Application no: H08-0241-15

Description: Erection of detached bungalow and garage - approved under H08-0968-14. Modification of Condition 2 to allow amendments to approved plans.

Location: Rear of 59 High Street
Gosberton
Spalding
Lincolnshire
PE11 4NJ
PE11 4NJ

Amendment: First floor side windows removed (dwg. nos. 2470-001B, 2470-002C and 2470-003B)

Date	Contract No	Drwg No
26.02.15	2470	001B

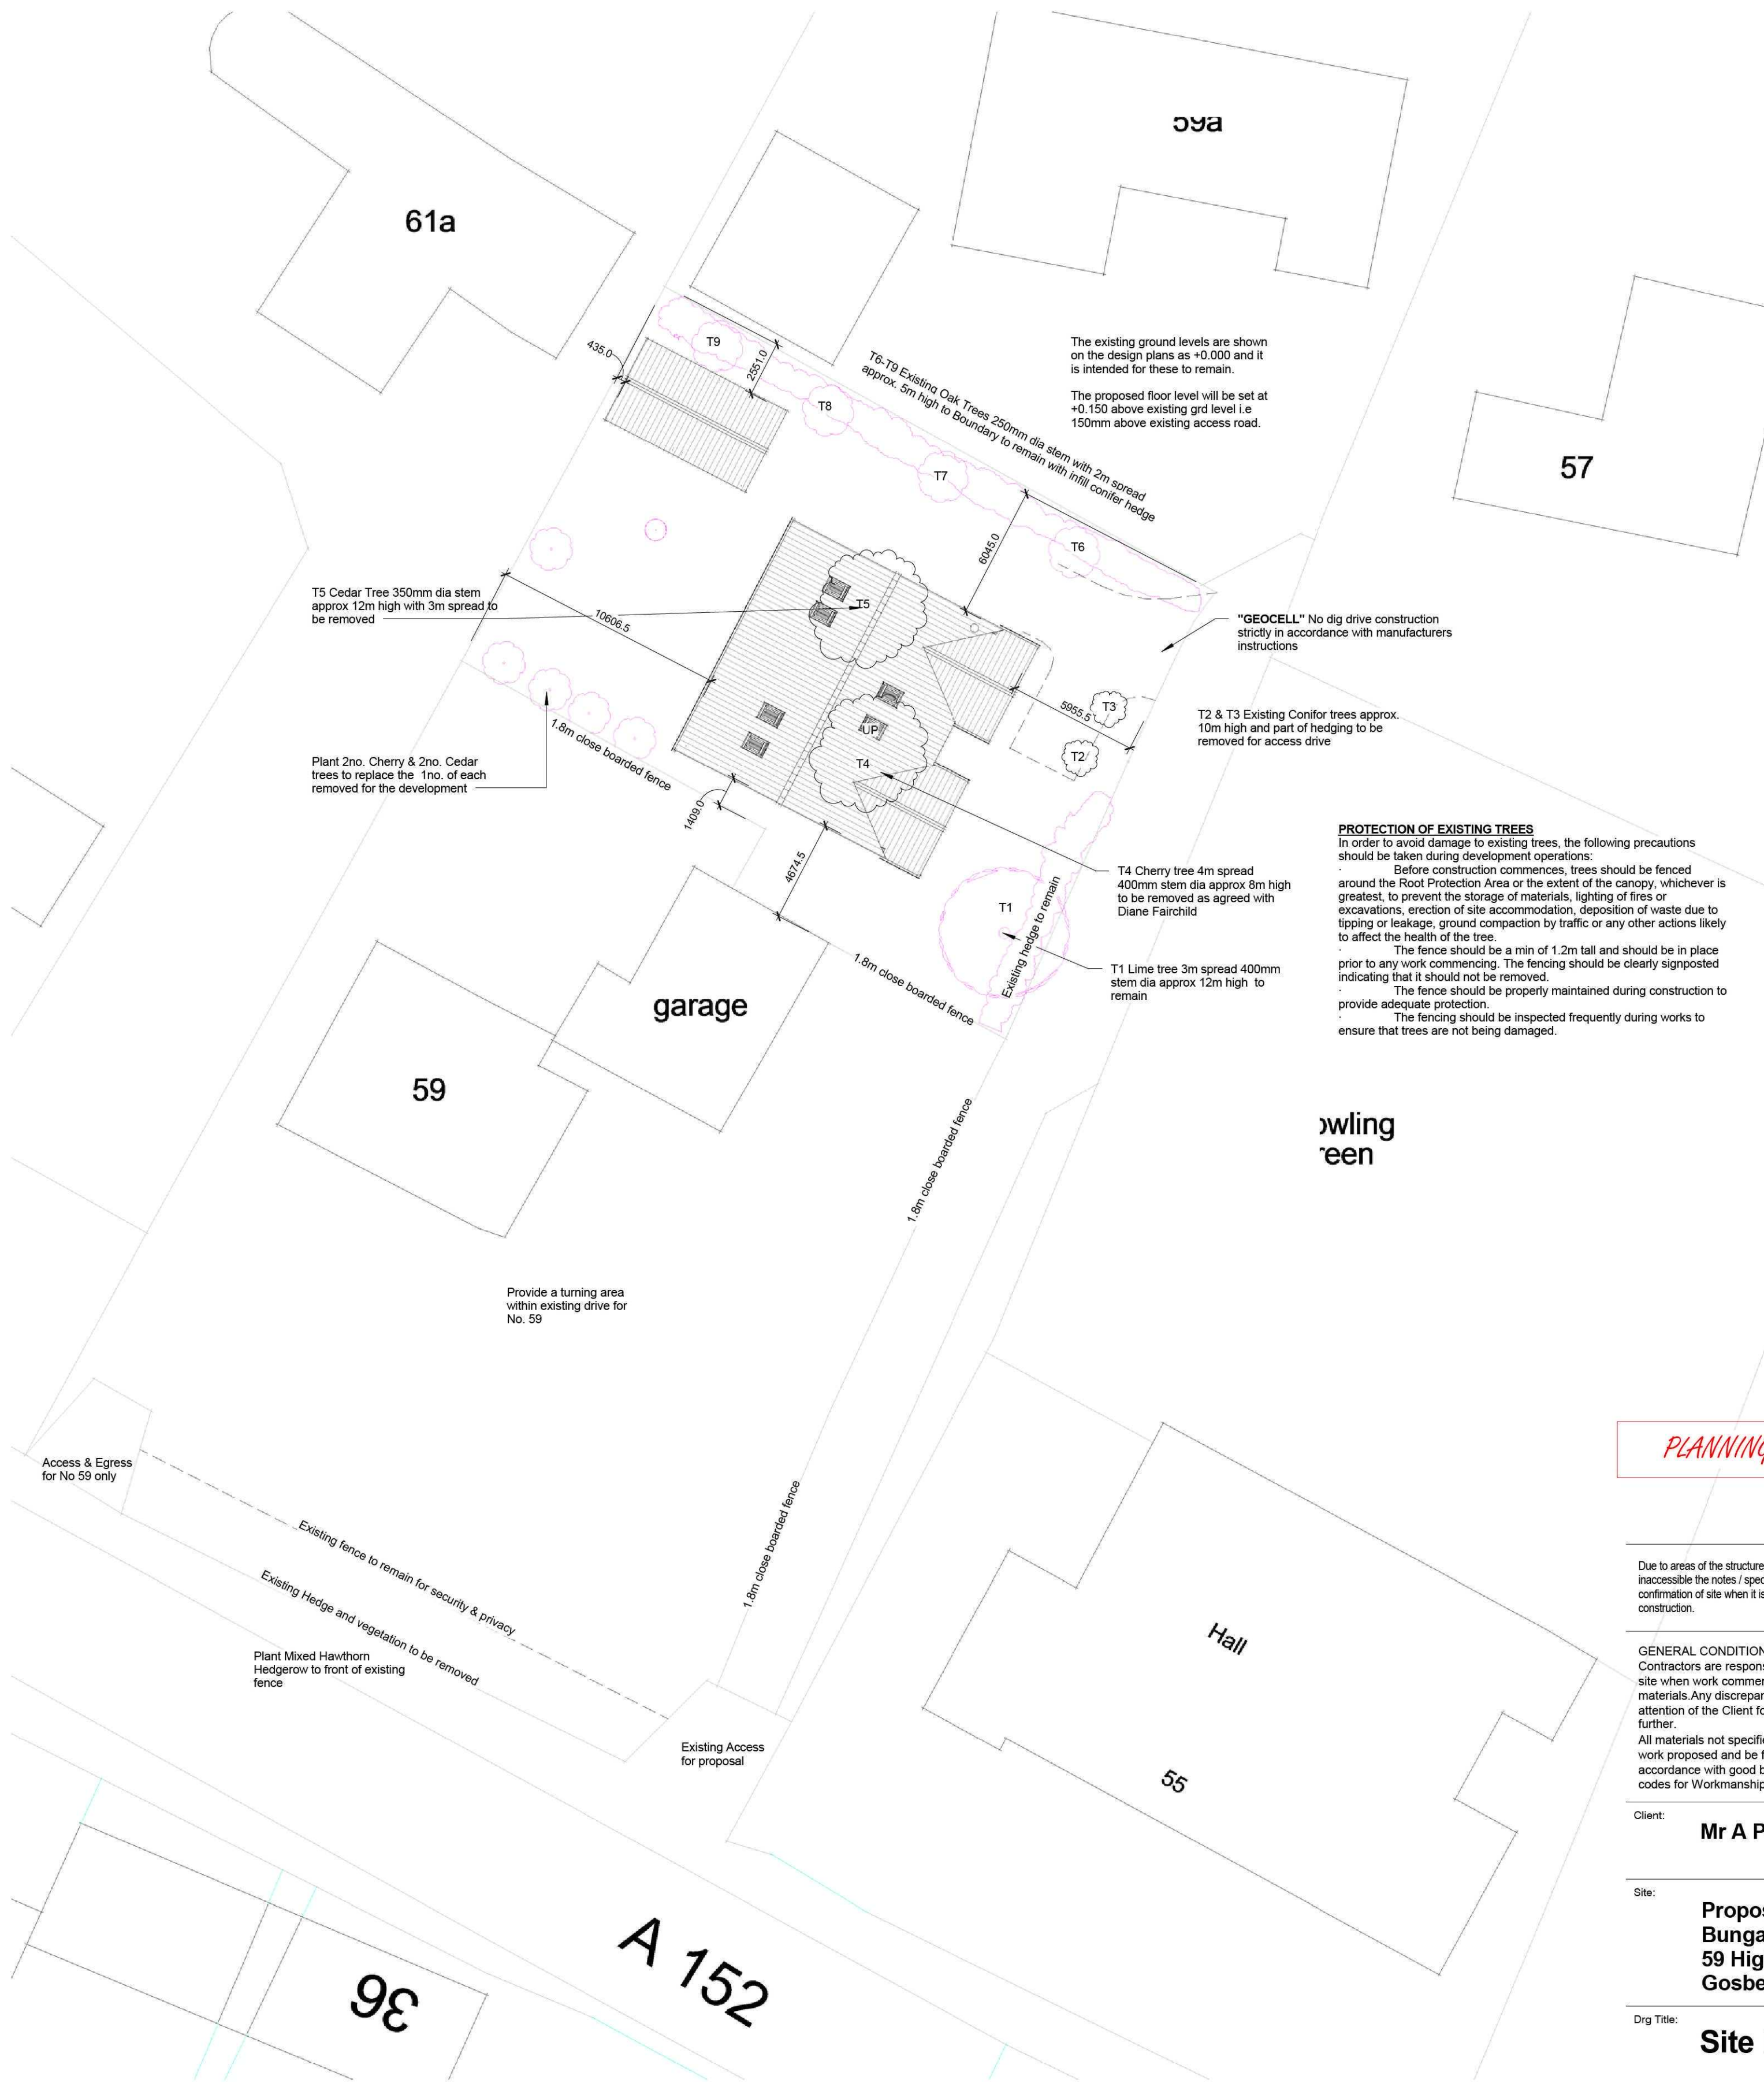
Regarding the amendment for 59 High Street, Gosberton, could you also submit amended plans 001 and 003 to include the changes to the windows.

Date 26.02.15	Contract No 2470	Org No 002C
------------------	---------------------	----------------

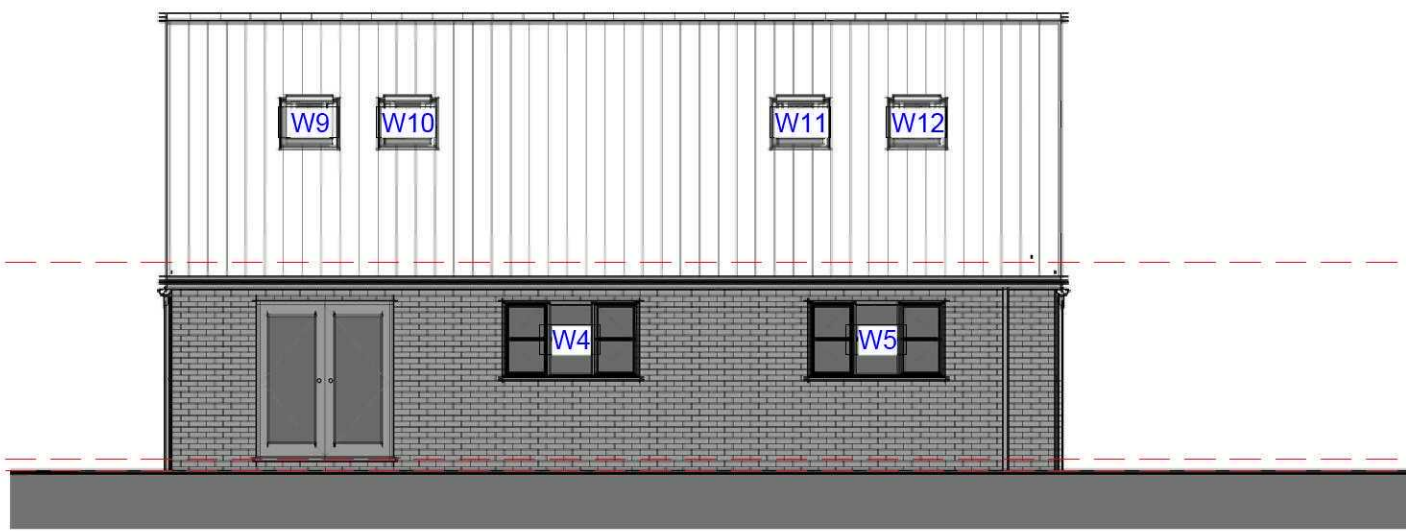
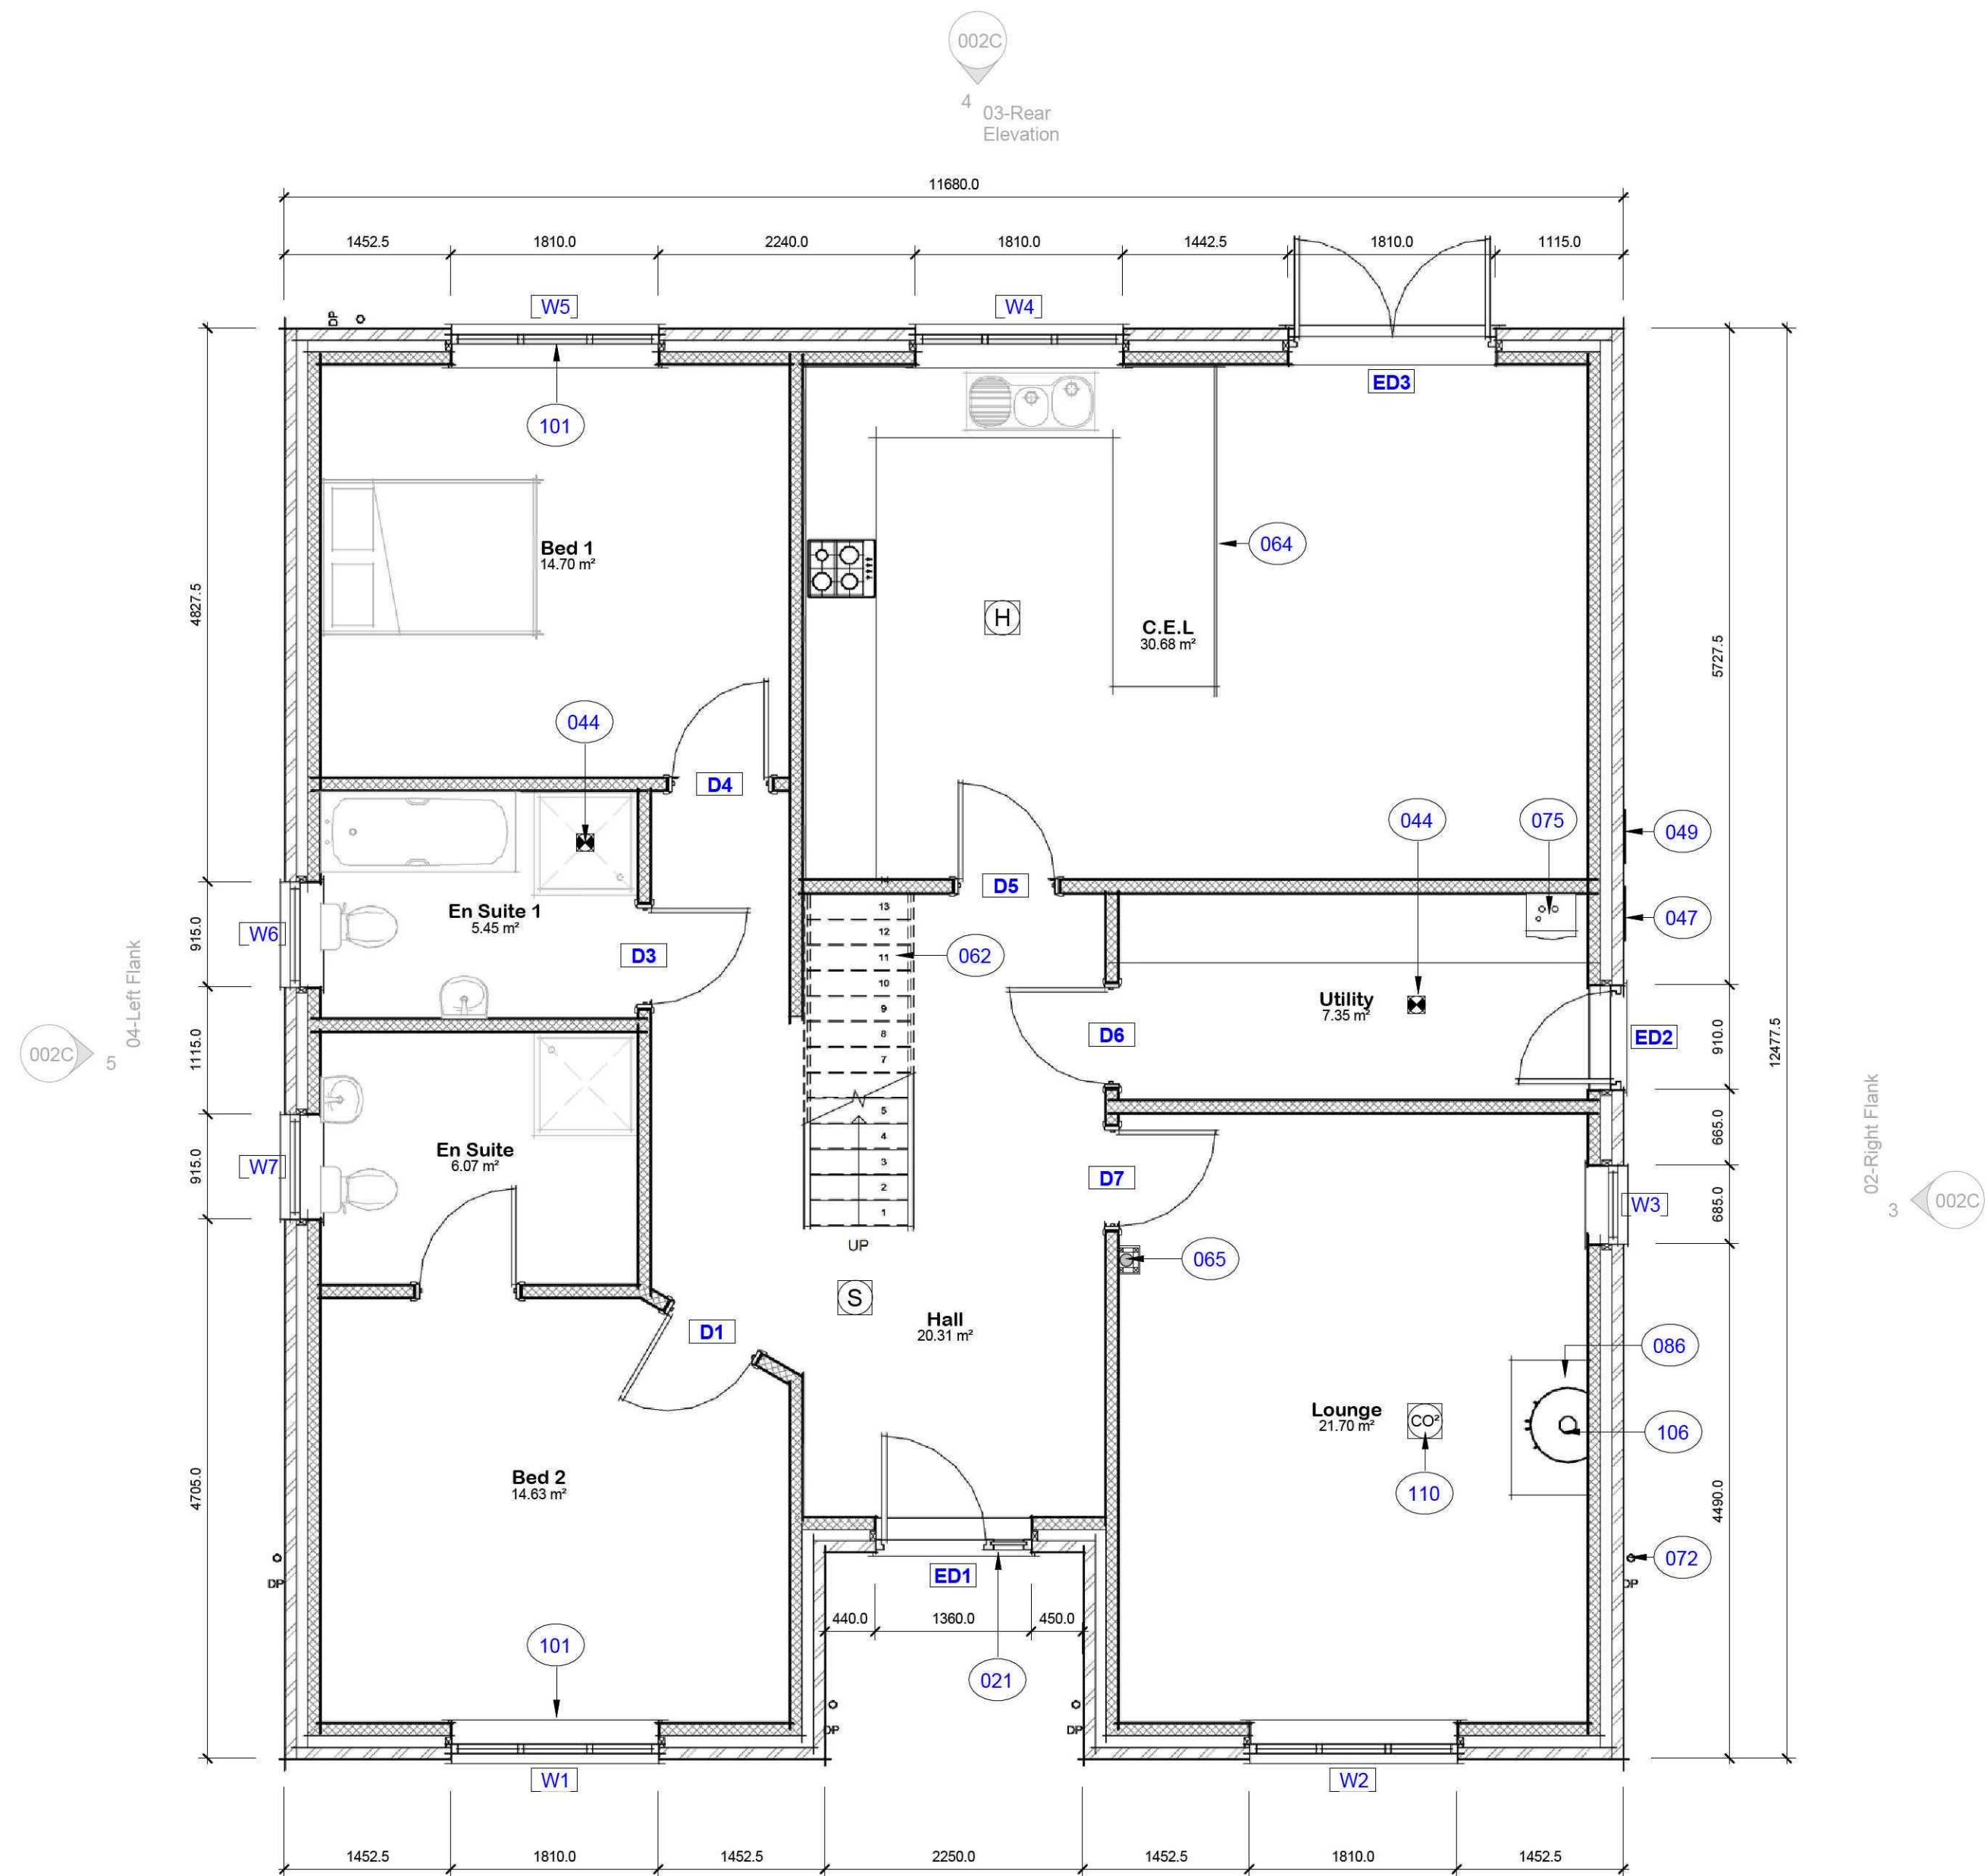
I have been out on site today and met a concerned neighbour (number 59) and the applicant/builder. Following this conversation it seemed that he was open to removing the proposed first floor windows in the side elevations and obscure glazing the roof lights to the rear. Obviously, you will want to confer with the applicant, but I think amended plans along these line would aid in removing current resident objections.
